Bolton Fold Farm, Alston Lane, Longridge

590-24-1 Highway Note on Matters Raised by LCC Highways

28th November 2024

Title
Forward Visibility from The Yard

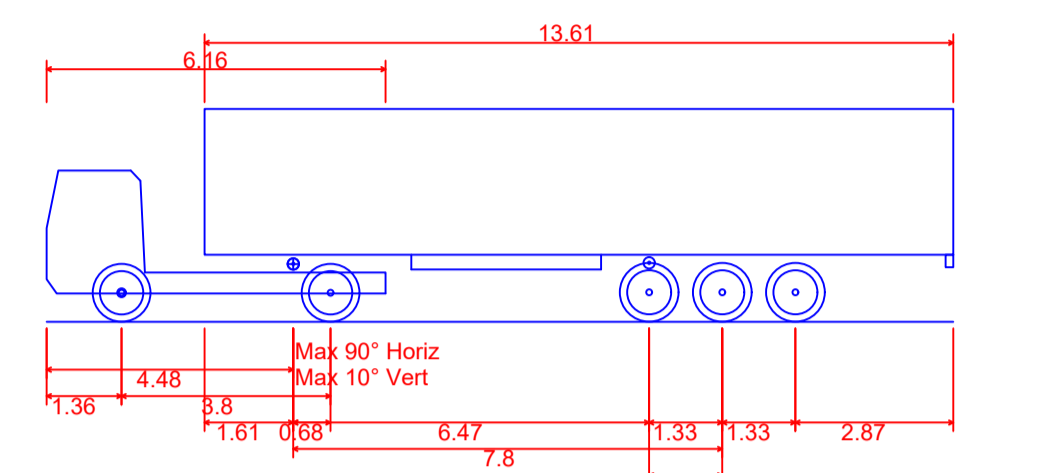
Site Access into the Yard

There will be minimum forward visibility of 41.2 metres for a vehicle approaching the site yard to see a vehicle leaving the site yard.

It is proposed to introduce a requirement for vehicles approaching the site yard to give way to vehicles leaving the site yard with the use of traffic signing and road markings. The arrangement is shown on drawing 590-24-1.

**Drawing Title**  
 PROPOSED SITE PLAN

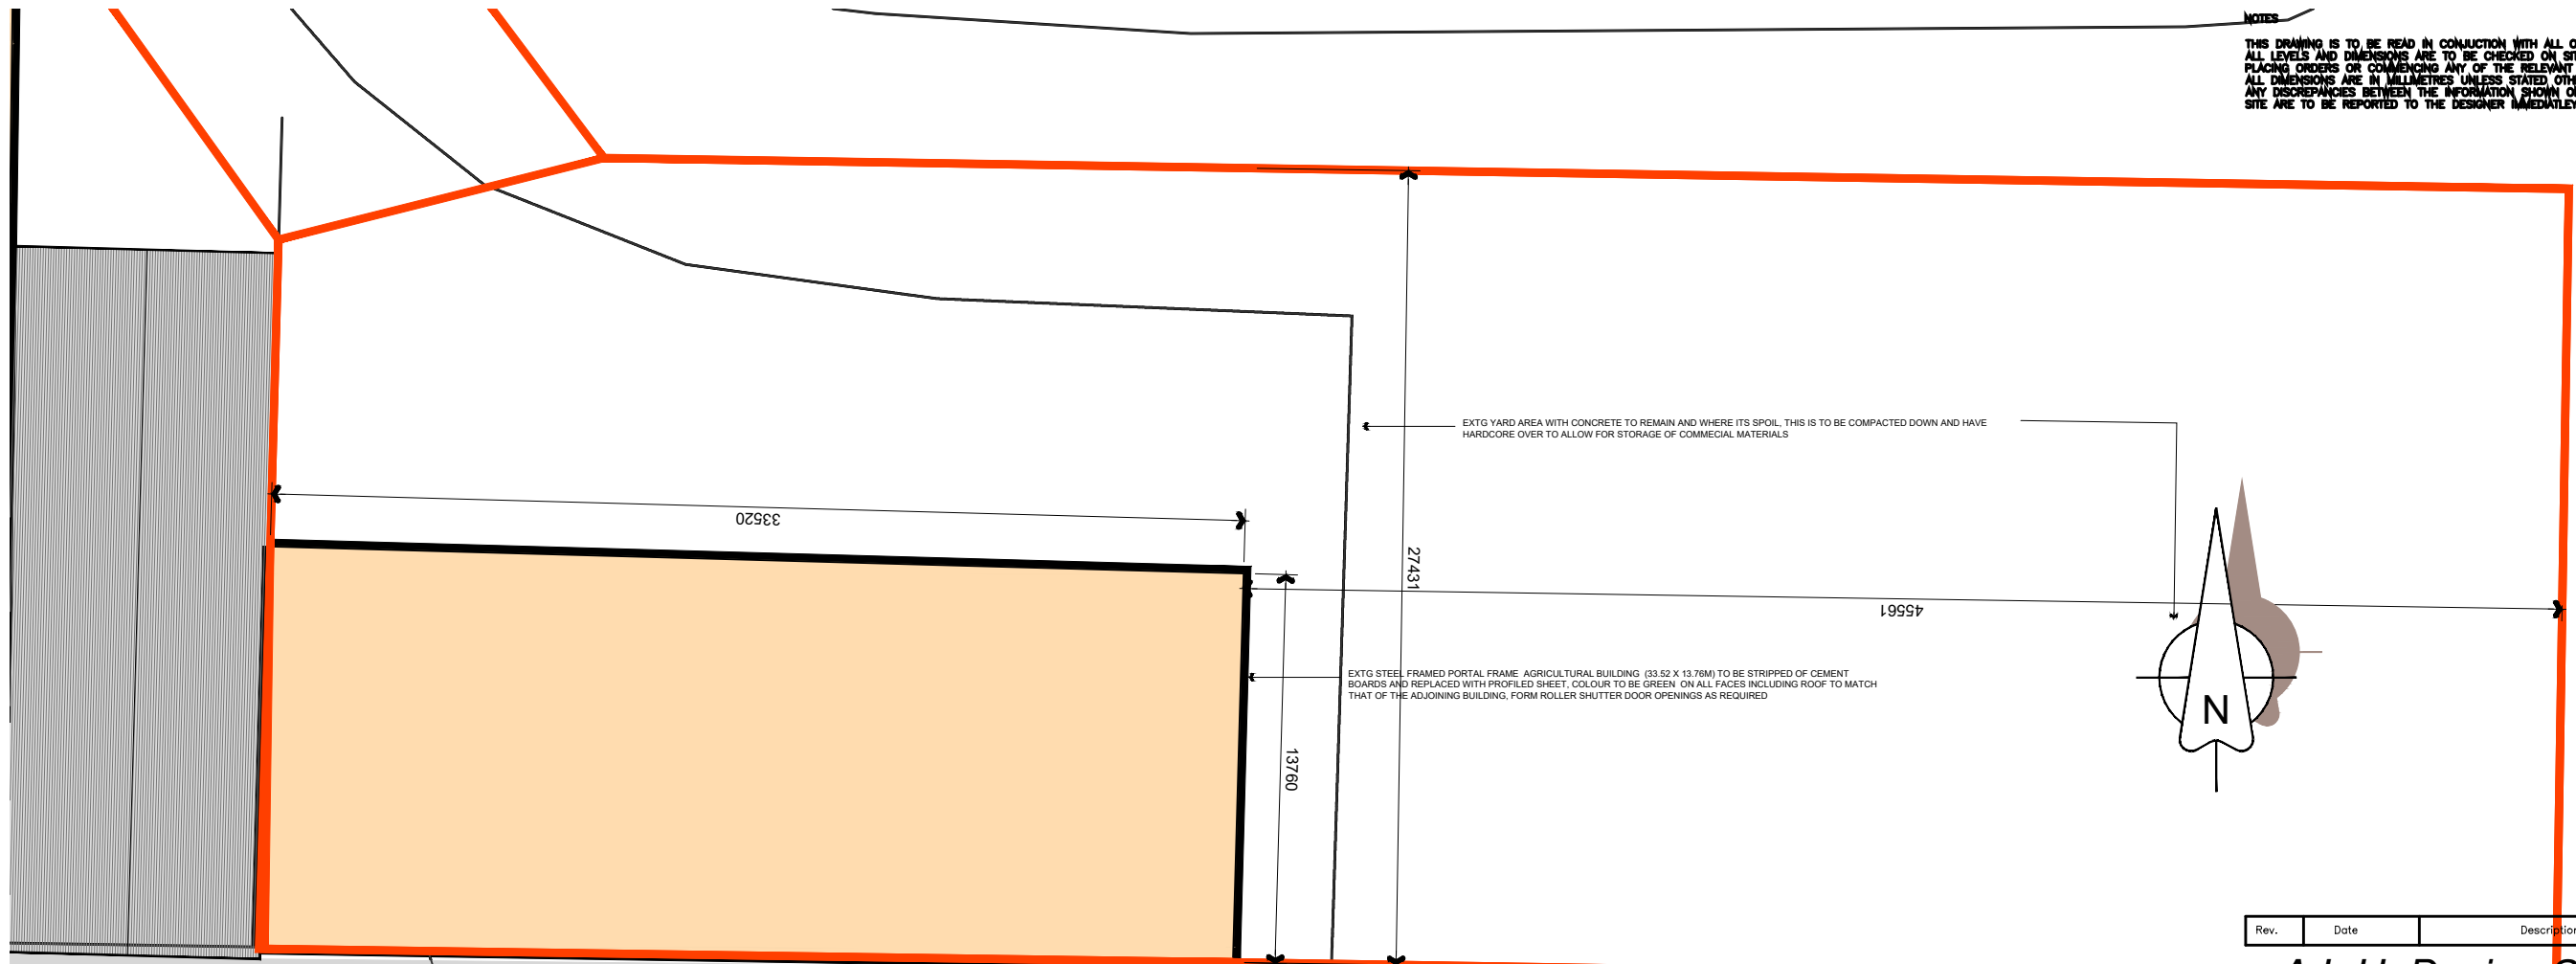
Parking

The Highways Officer asked for the scheme to be considered against the Joint Lancashire Structure Plan. The building will provide a place for storage of scaffolding boards and poles and would seem to fit with B8 Warehouse in the JLSP. B8 has a typically parking requirement of 1 space per 200m² for a low accessibility site.

The building dimensions are approximately 33.52 metres x 13.76 metres, providing a floor area of approximately 461m², which would require 3 car parking spaces.

The site layout proposes 3 vehicular parking spaces adjacent to the building as shown above. This is considered sufficient for the needs of the development. The building will have 3 staff which can be accommodated in the 3 parking spaces.

Title
Vehicle Tracking from the Site Yard with Articulated Vehicle

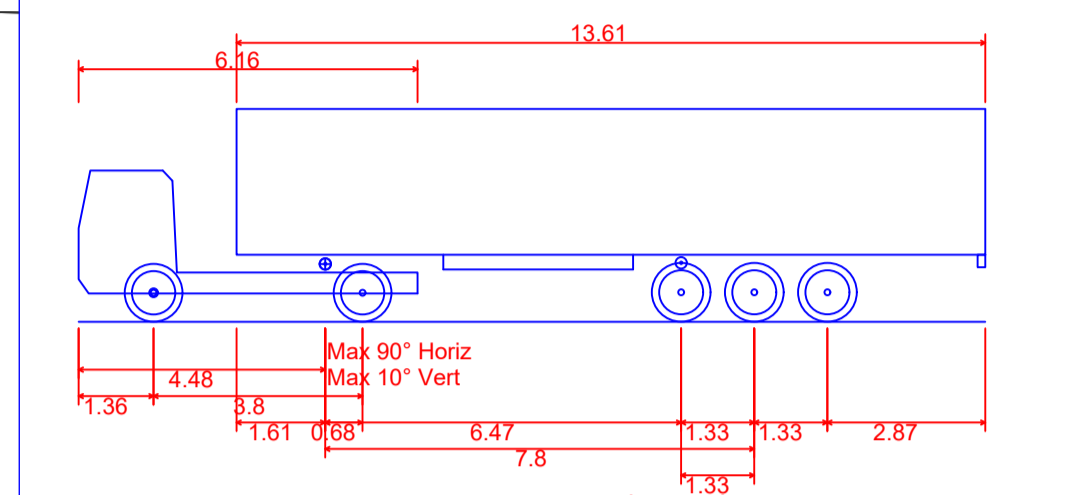
Access by Large Vehicles Along the Service Road and to / from the Site Yard

Swept path analysis has been undertaken using an articulated vehicle to assess how the vehicle would move along the site access road, into and out of the site yard and around the site yard. Drawings 590-24-3 and 4 show the swept path analysis. It is considered that the large vehicle can move along and around the site in a safe manner with the provision of signing and road marking mentioned above.
